ENG-SF21032-R2-CDs.pdf Markup Summary

Subject: Callout
Page Index: 1
Date: 3/22/2022 3:18:55 PM
Author: dsdrice
Color: ■
Layer:
Space:
Page Label: [1] 1 CV01- Street Plans - CV01

**PENNYDALE DR
STA 7+00.00 TO 12+00.00**

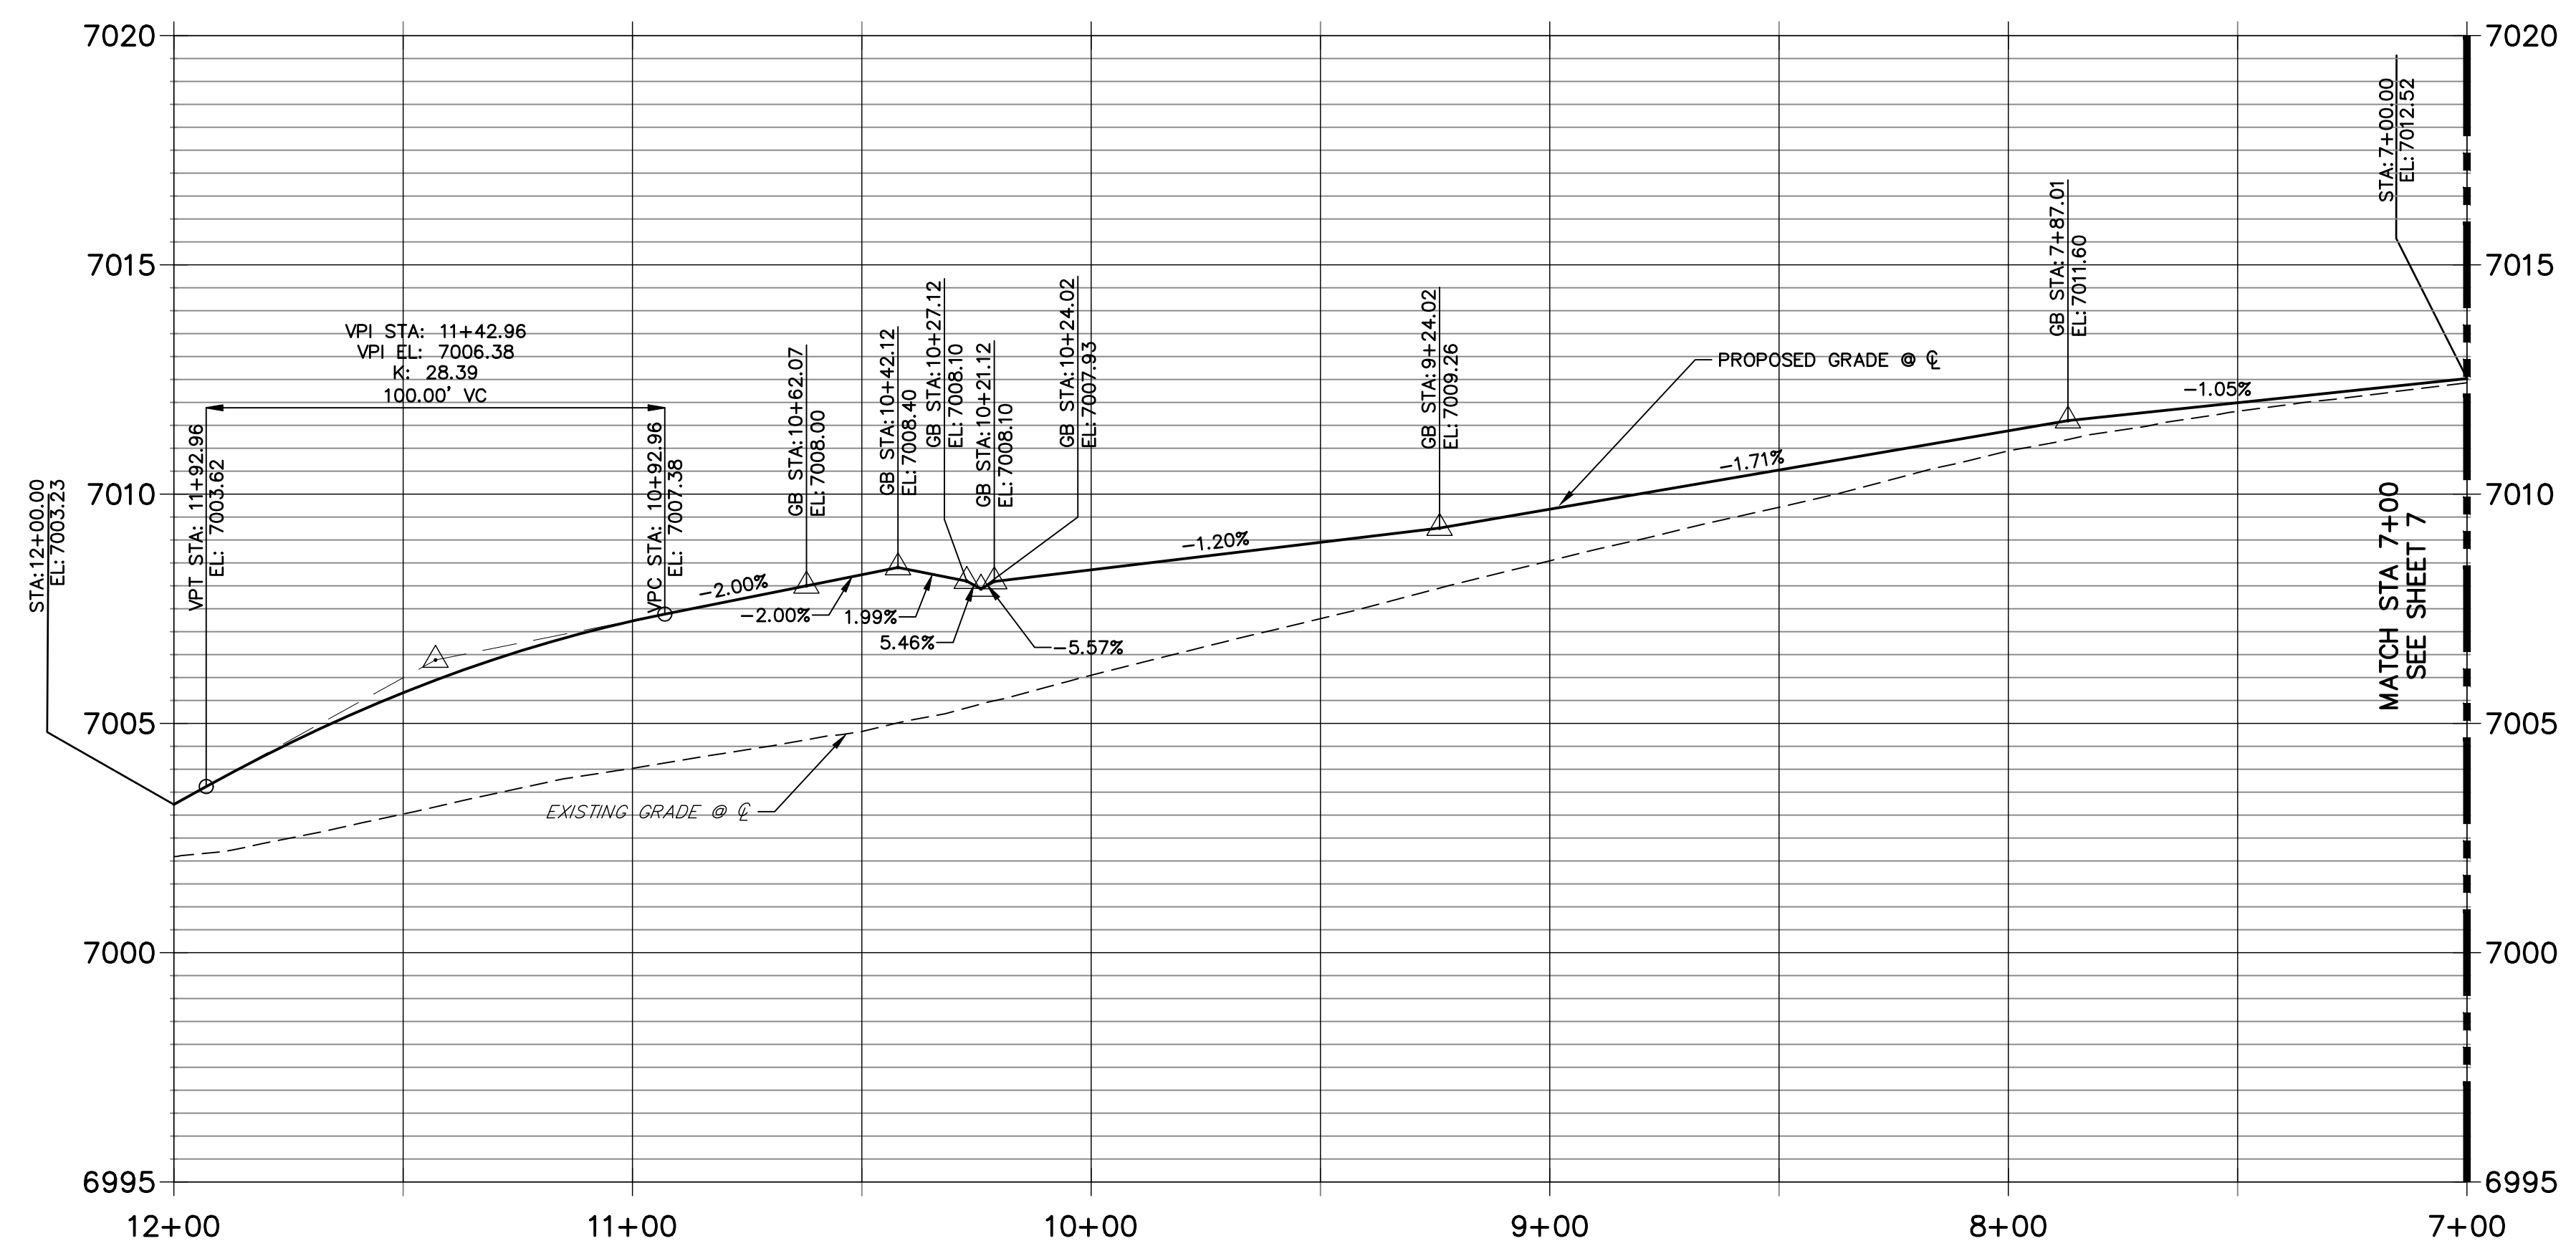
Please label cross-slopes

If the profile can be raised to aid in gutter drainage that is recommended.

STERLING RANCH FILING 3 STREET IMPROVEMENT PLAN	SHEET 11 OF 13
JOB NO. 25188.00

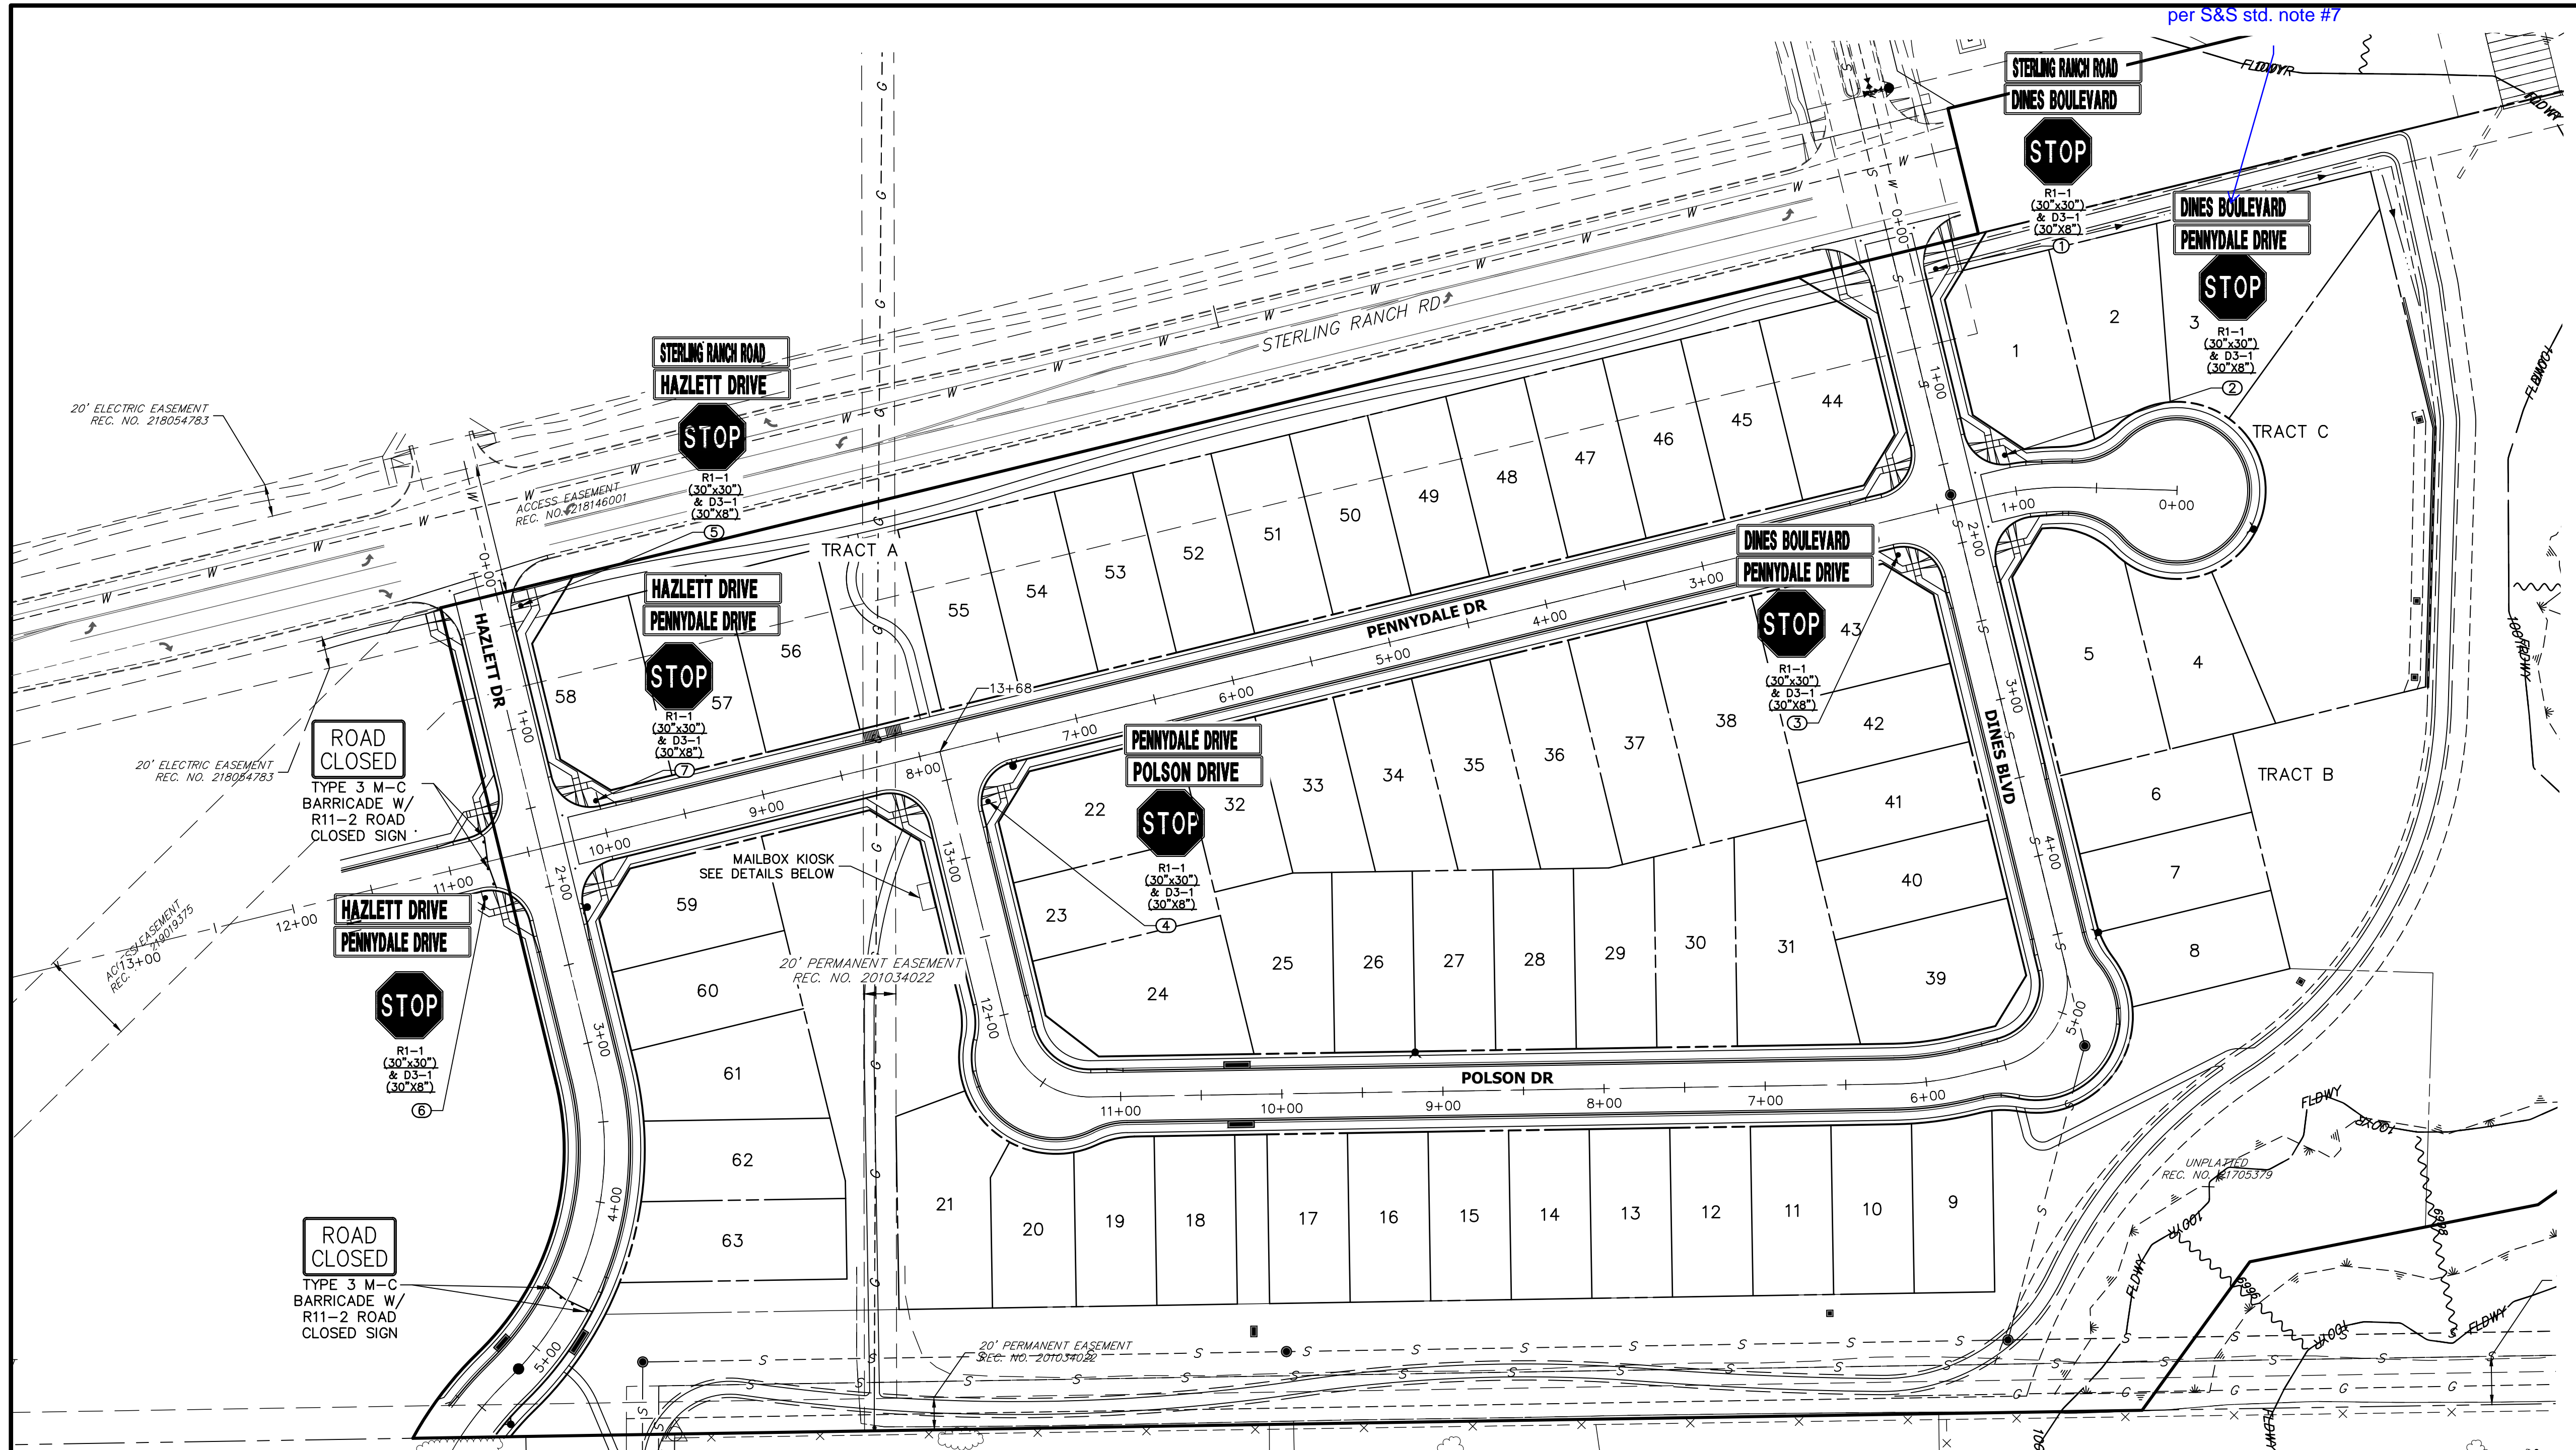
Lettering and abbreviations need to be per S&S std. note #7

**STERLING RANCH PHASE 2 EX. GAS LINE PROFILE
STA 0+00.00 TO 10+78.71**

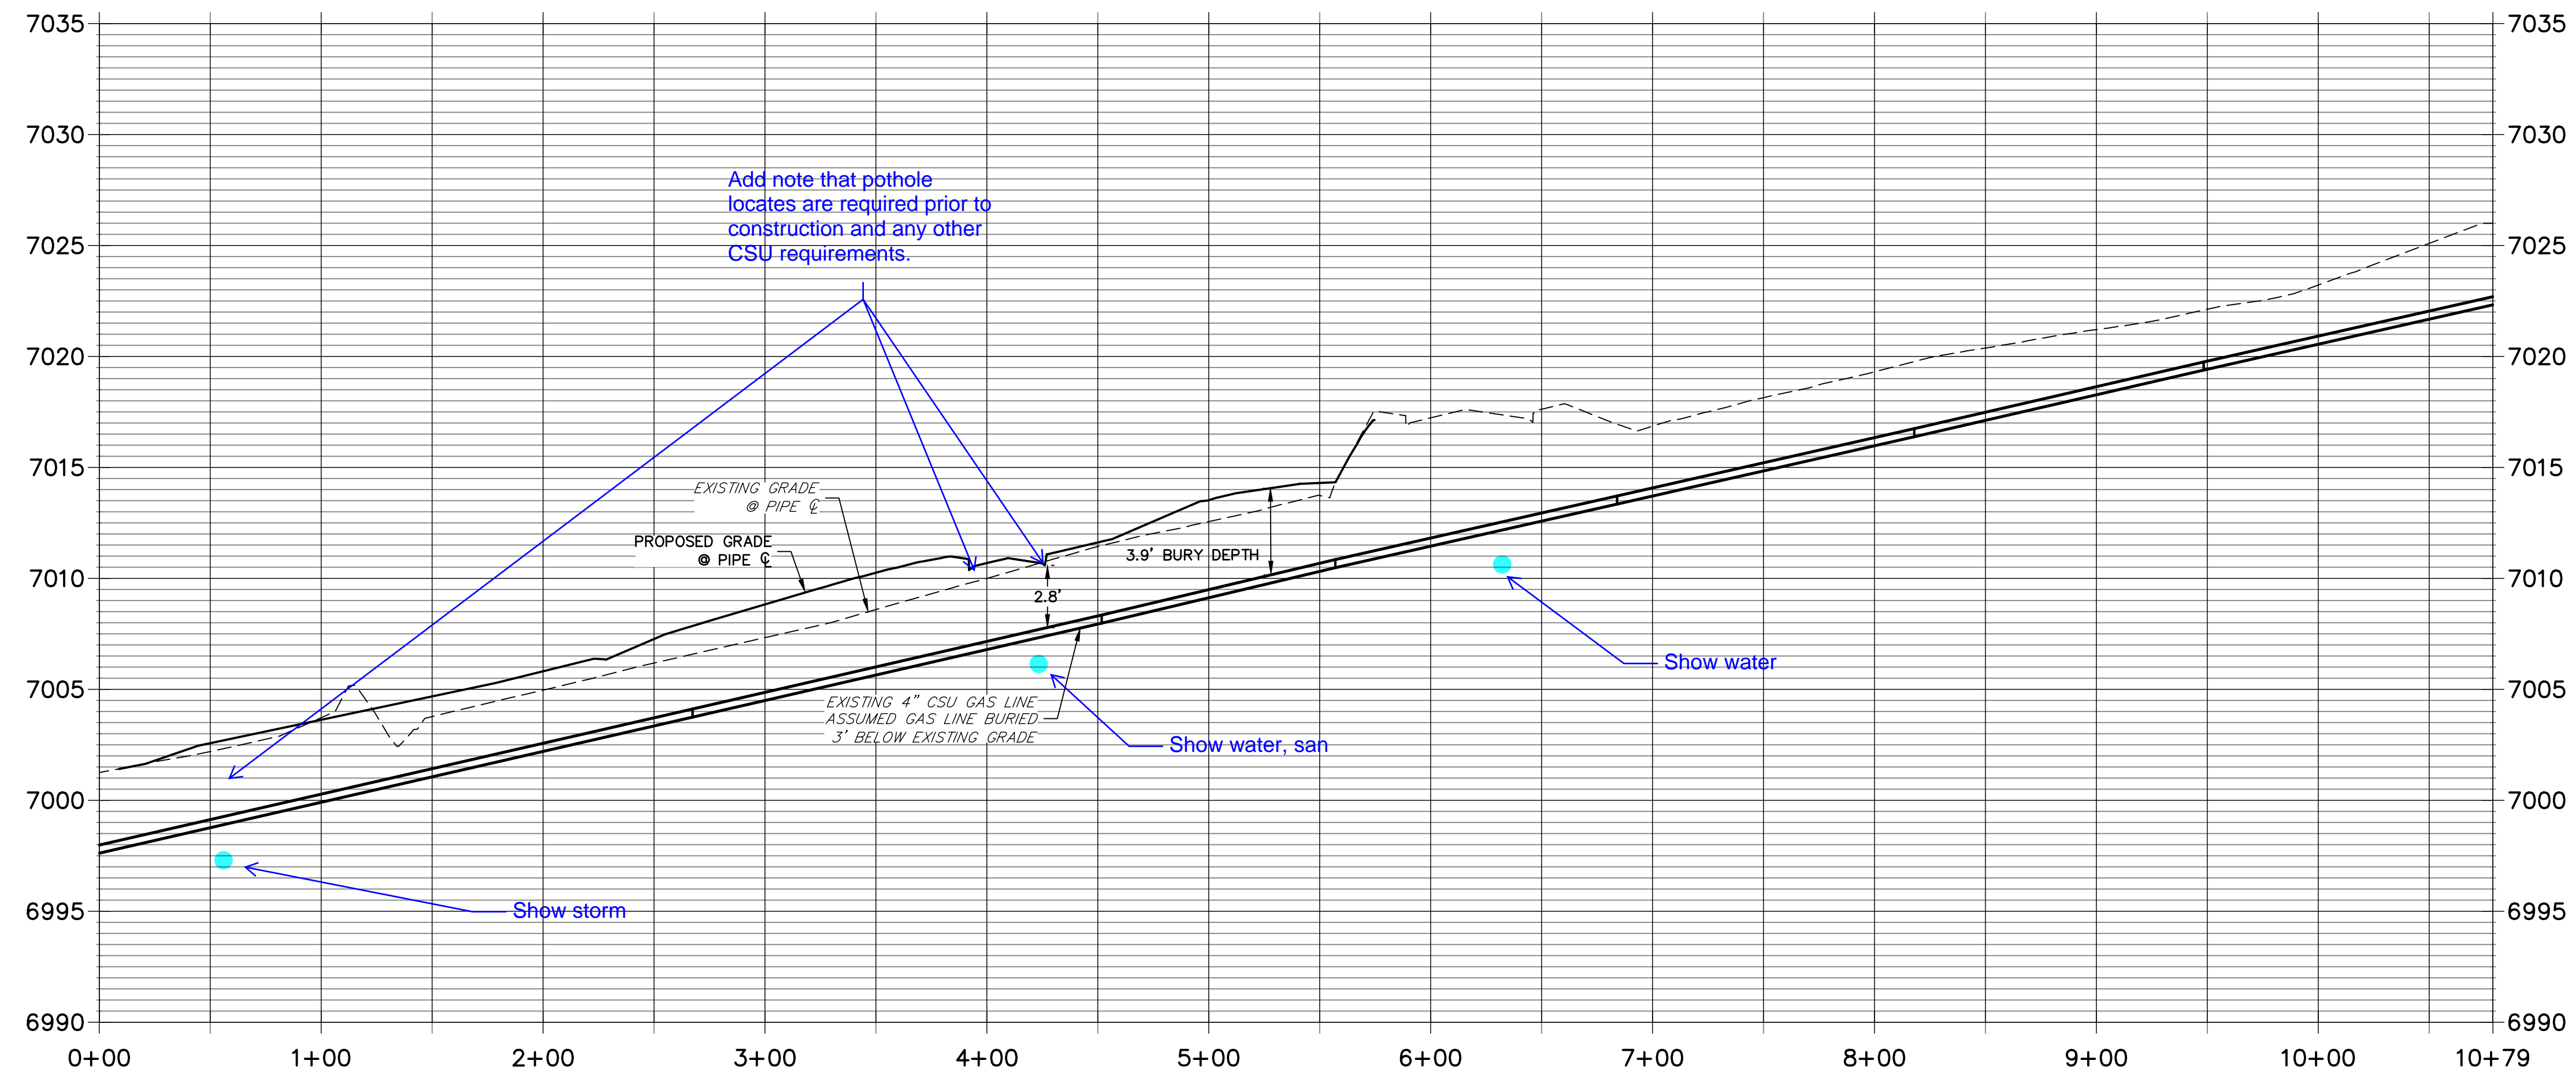
Show storm

Show water, san

Show water

Add note that pothole locates are required prior to construction and any other CSU requirements.
